Your ref: SSD-78996460
Our ref: DOC25/361505

**Subject: Residential development with infill affordable housing – SSD-78996460–
Environmental Impact Statement**

Thank you for your referral received 29 April 2025 requesting advice from the Conservation Programs Heritage and Regulation (CPHR) Group on the Environmental Impact Statement (EIS) for this State Significant Development (SSD-78996460) located at 16-24 Lord Street and 21-27 Roseville Avenue, Roseville.

CPHR response on the EIS for residential development with infill affordable housing – SSD-78996460

Figure 16 Proposed flood wall

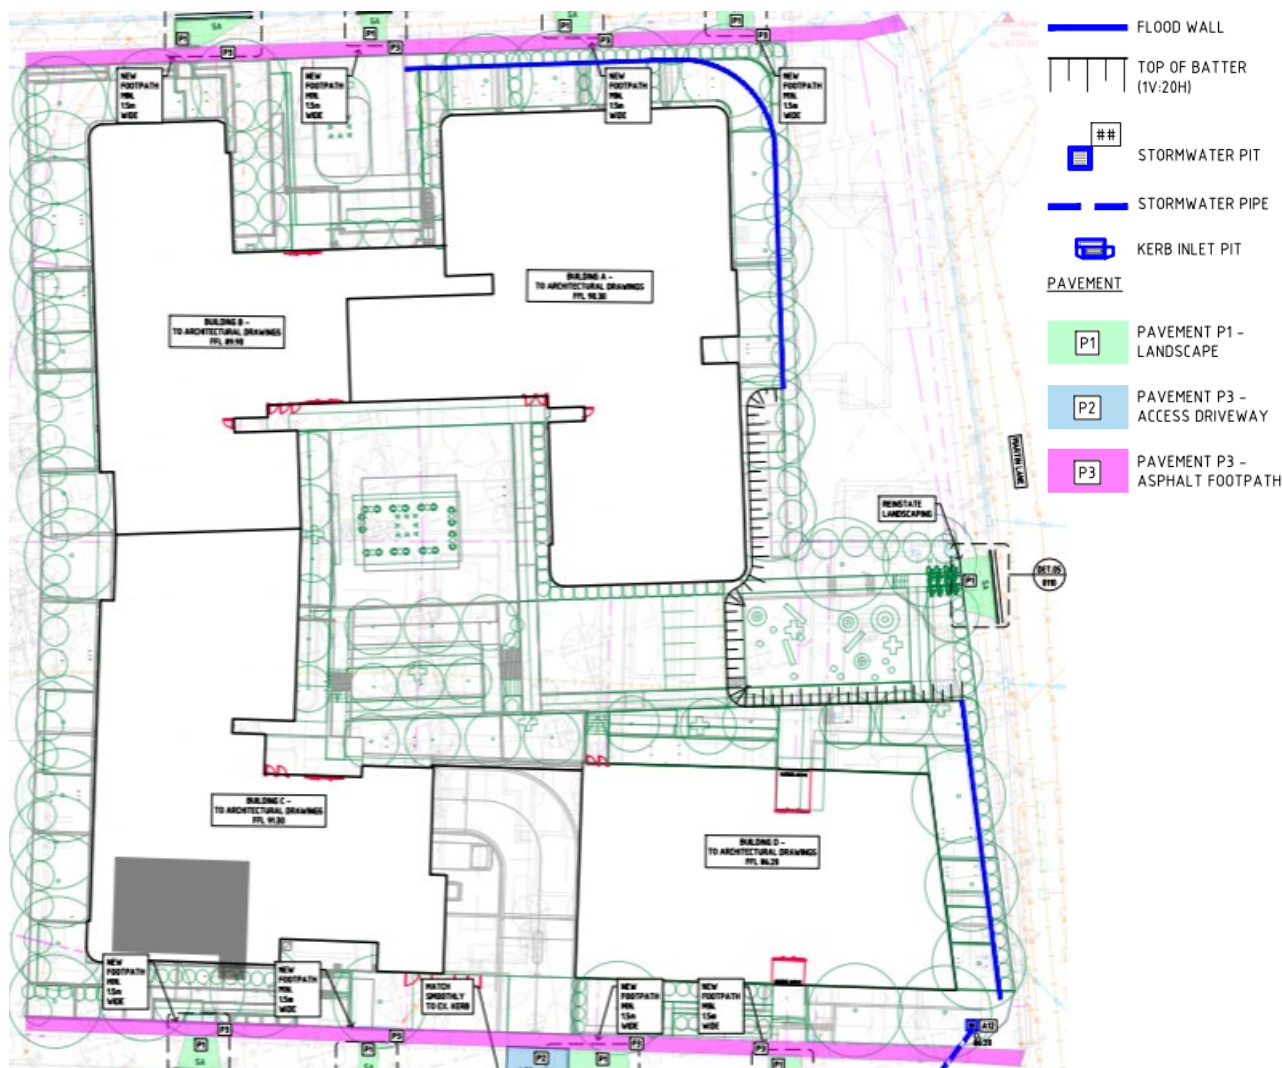
The Flood Report provides brief information on the flood behaviour in the 1% AEP and PMF for the developed condition. The Flood Report proposes the implementation of a barrier wall starting at 25 Roseville Avenue to the south-eastern boundary at the intersection of Martin Lane and Lord Street to provide flood immunity for flood events up to and including the 1% AEP. However, the Flood Report also proposes setting the flood planning level lower than the required 1% AEP plus freeboard stating, “The habitable floor level may be set lower as the proposed flood wall is providing protection to the Design Flood Standard.” CPHR highlights that this is not acceptable. The minimum floor levels generally relate to specific development standards, such as the flood planning levels (FPLs), relevant to the development type. Development standards do not change by the implementation of mitigation measures such as a barrier wall. The habitable floor level must not be less than the 1% AEP plus freeboard. Recommended action: The Flood Report should be updated to: • provide information on flood behaviour, flood constraints and flood risk for the full range of flooding for both existing and post developed conditions • set the habitable floor level at not less than the 1% AEP plus freeboard.
